## **SSD 7382 MOD 1 - RESPONSE TO REQUEST FOR ADDITIONAL INFORMATION UTS CENTRAL**

This letter is in response to a request for additional information for the proposed Section 96 Modifications to the UTS Central Project (SSD 7382). This letter has been prepared by JBA on behalf of the University of Technology Sydney (UTS) and is based on supporting documentation including:

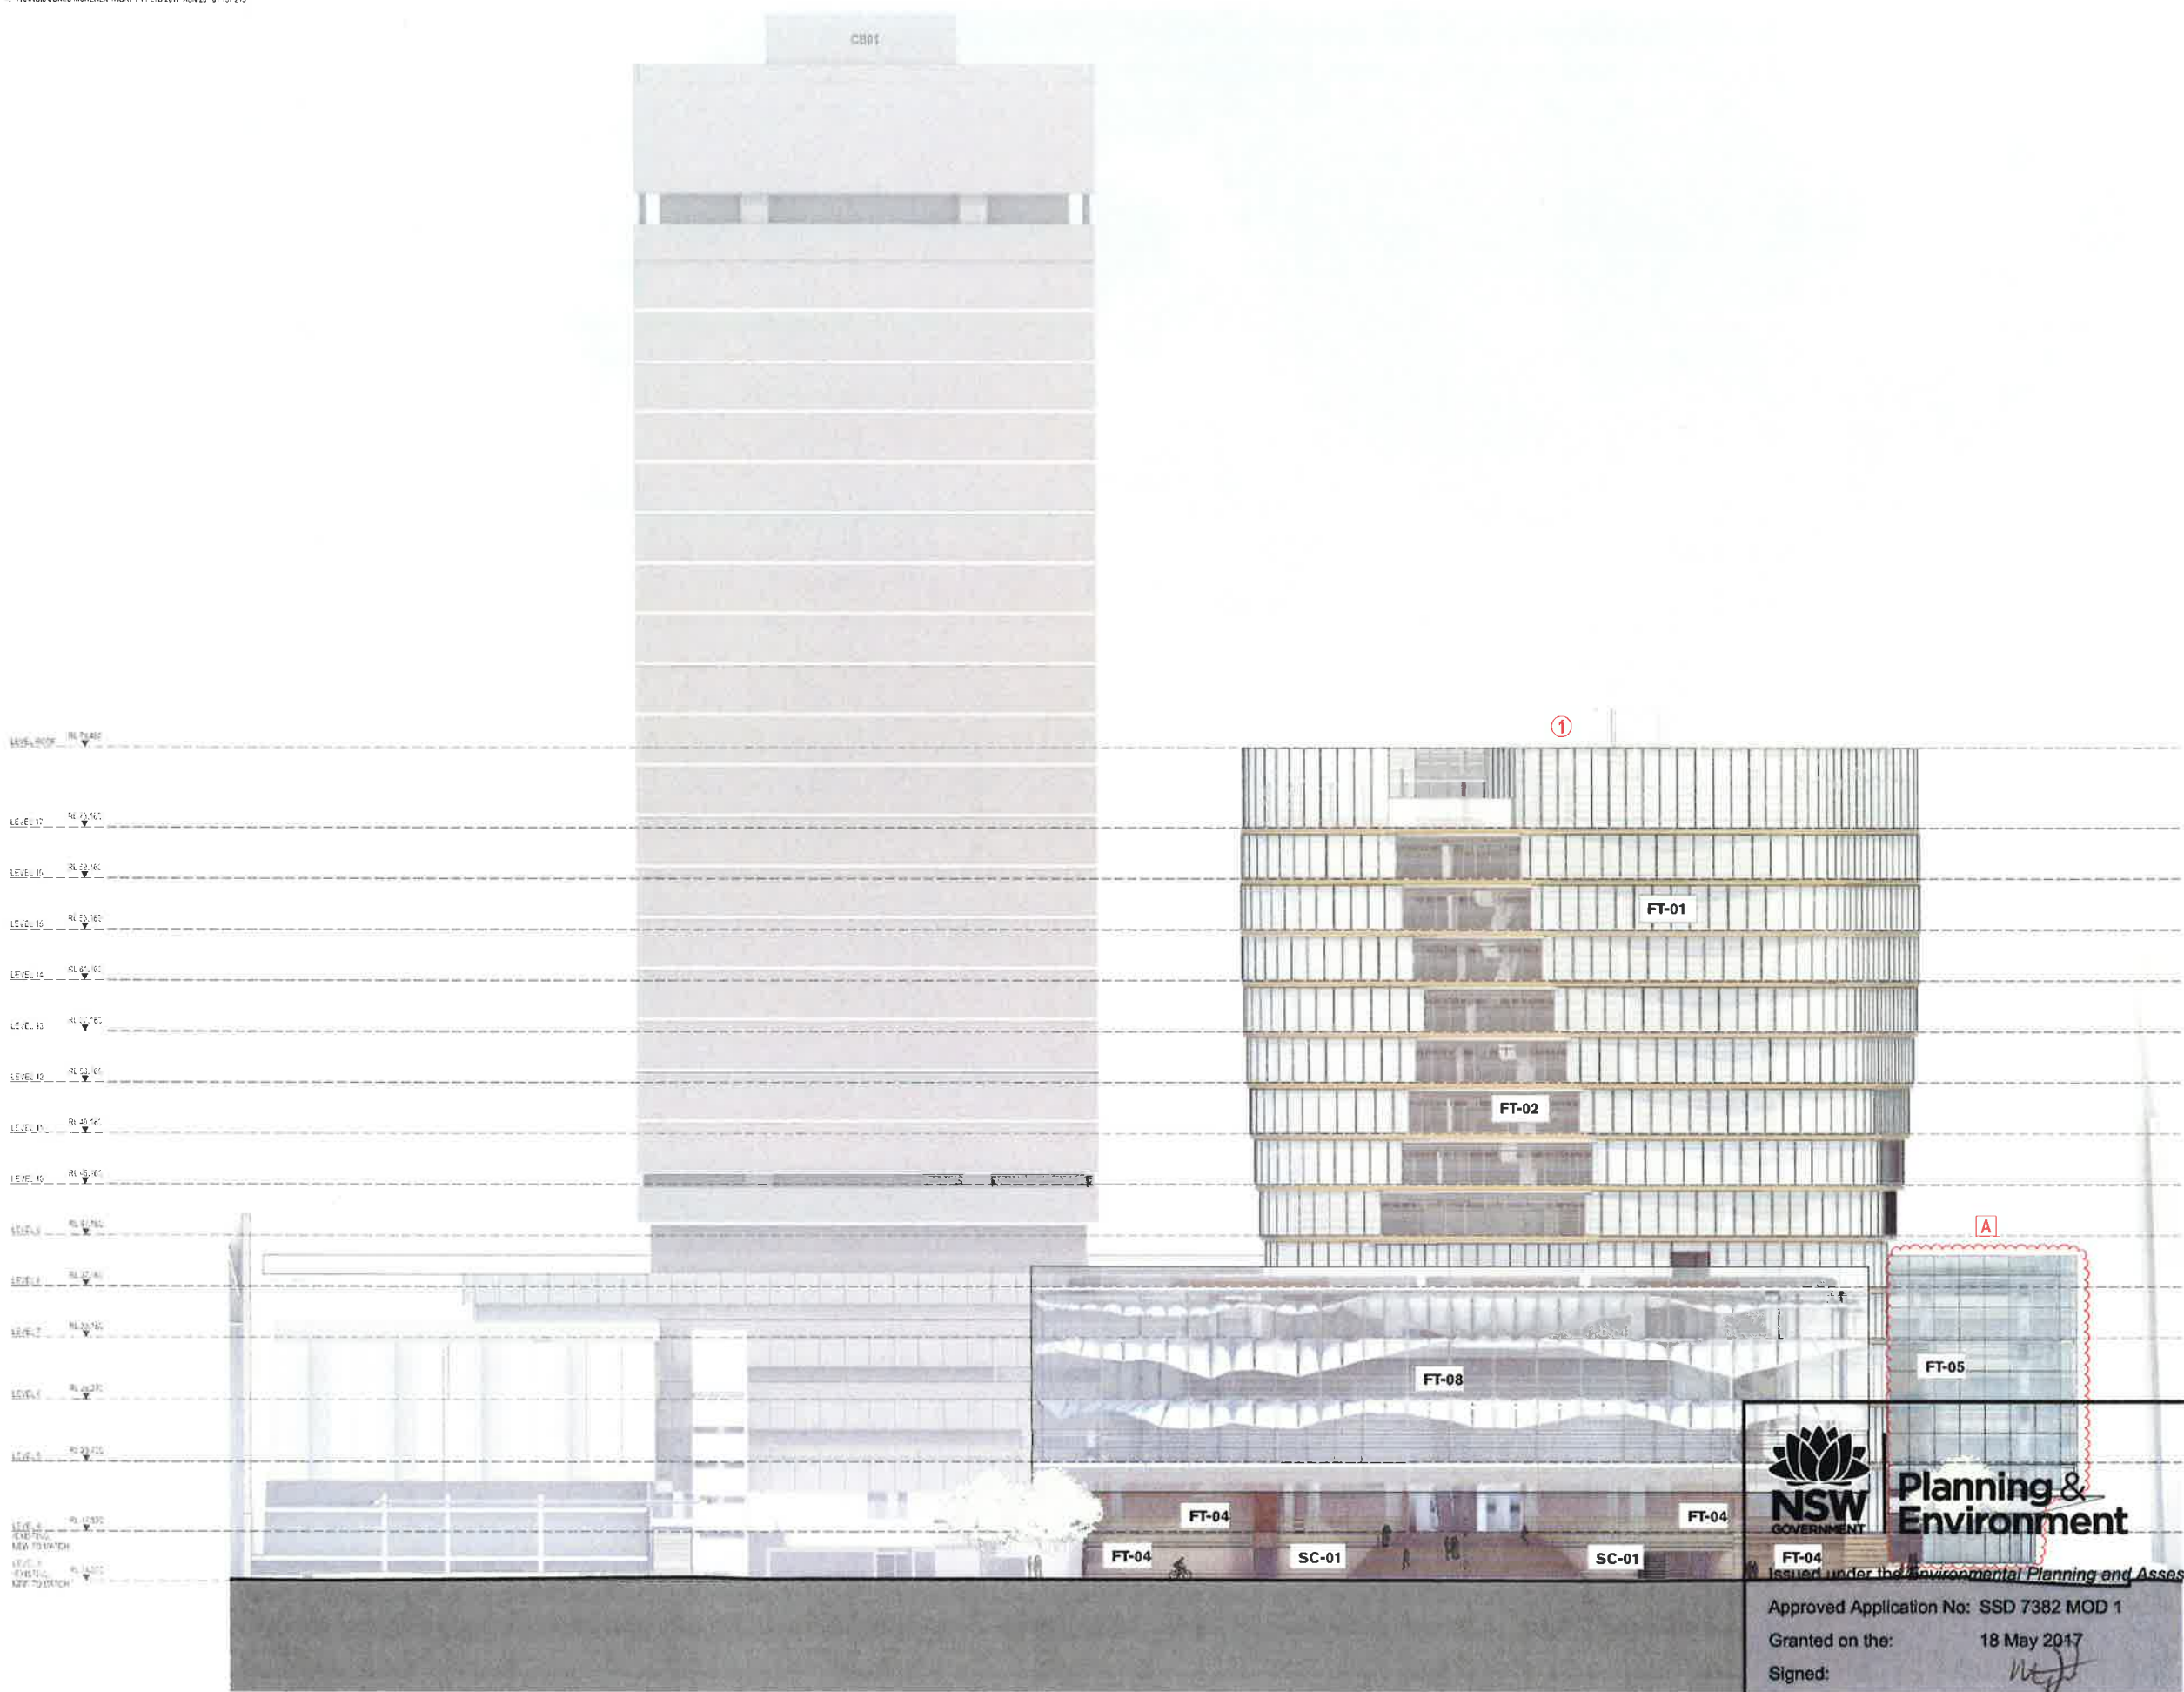
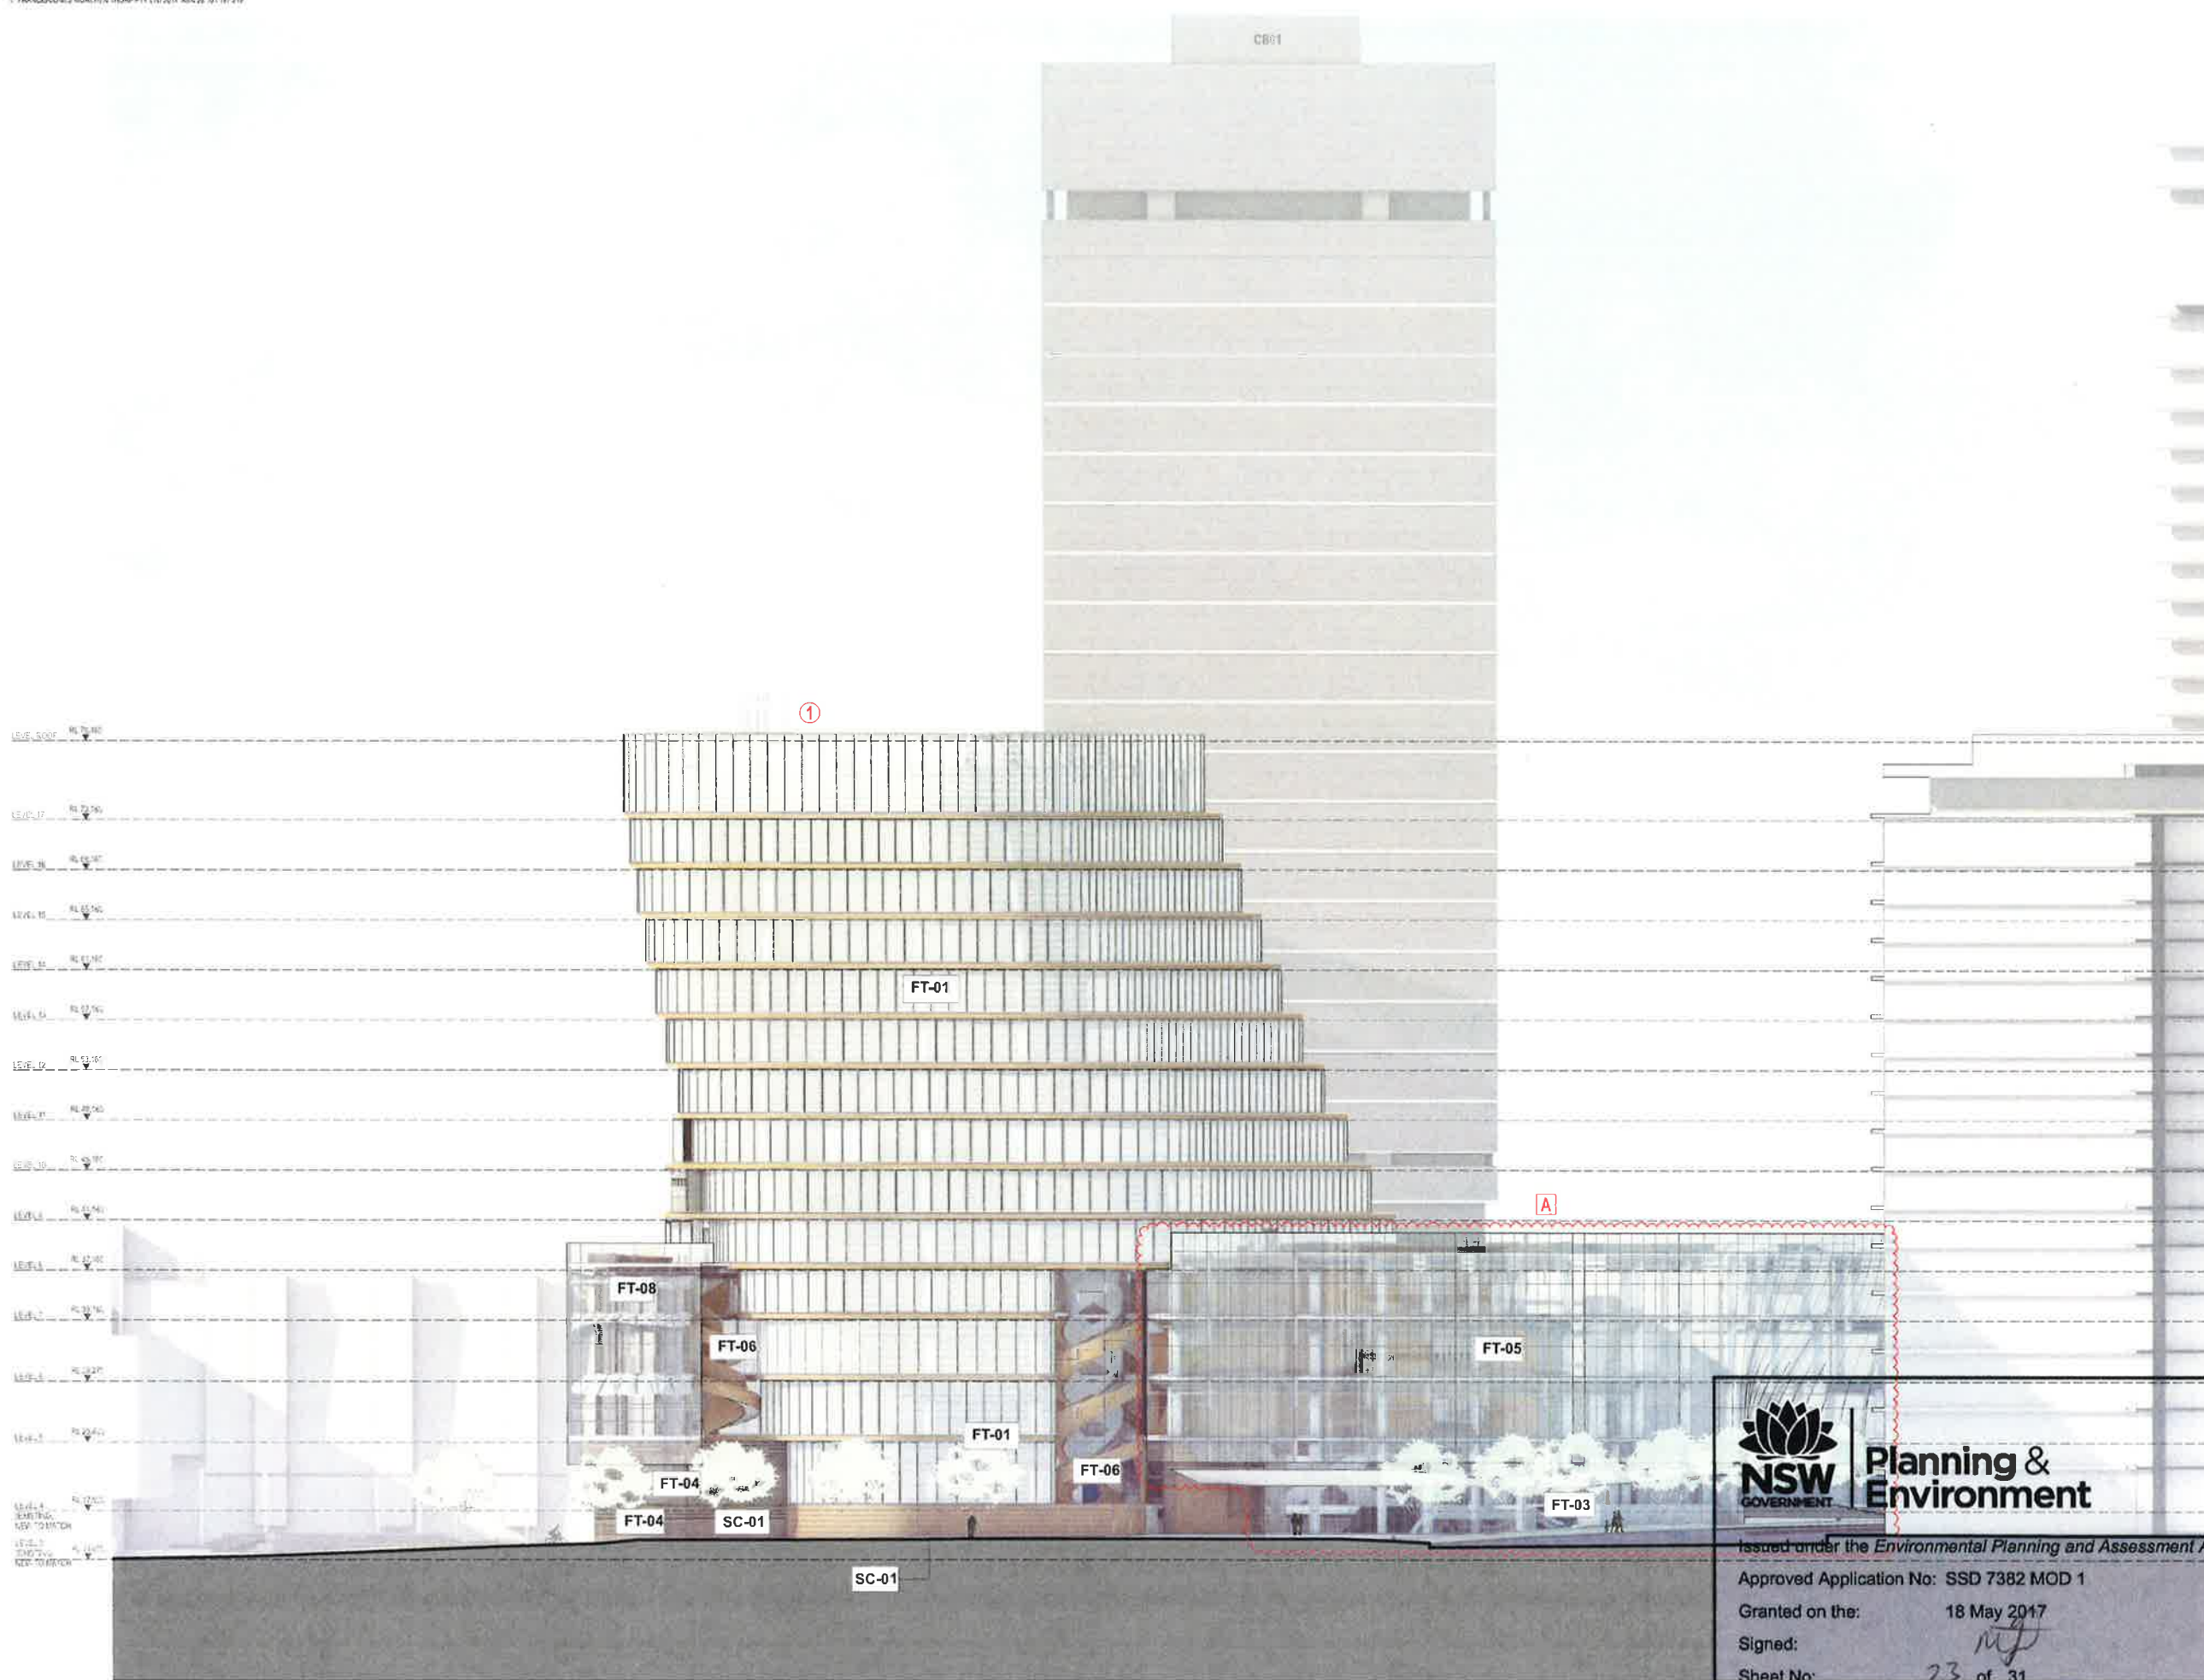
*The façade should show a closer relationship to the competition winning entry which includes curvature in the façade in three dimensions (plan and section);*

- **Appendix A** includes diagrams demonstrating in plan that the proposed façade as per the s96 reflects the competition entry.
- **Appendix B** provides a written statement from design architects *DJRD* and *Lacoste + Stevenson* confirming the Broadway façade as depicted in the current S96 application faithfully represents the design intent of the original competition-winning scheme.
- The Broadway façade has maintained the curvature in the façade in three dimensions. This is most apparent at the entry from Broadway as consistent with the Concept Design intent. There have been ongoing discussions with façade specialists as to how this curvature may be achieved while provided a consistent legibility of Phase 1 and 2 across the entire Broadway façade.
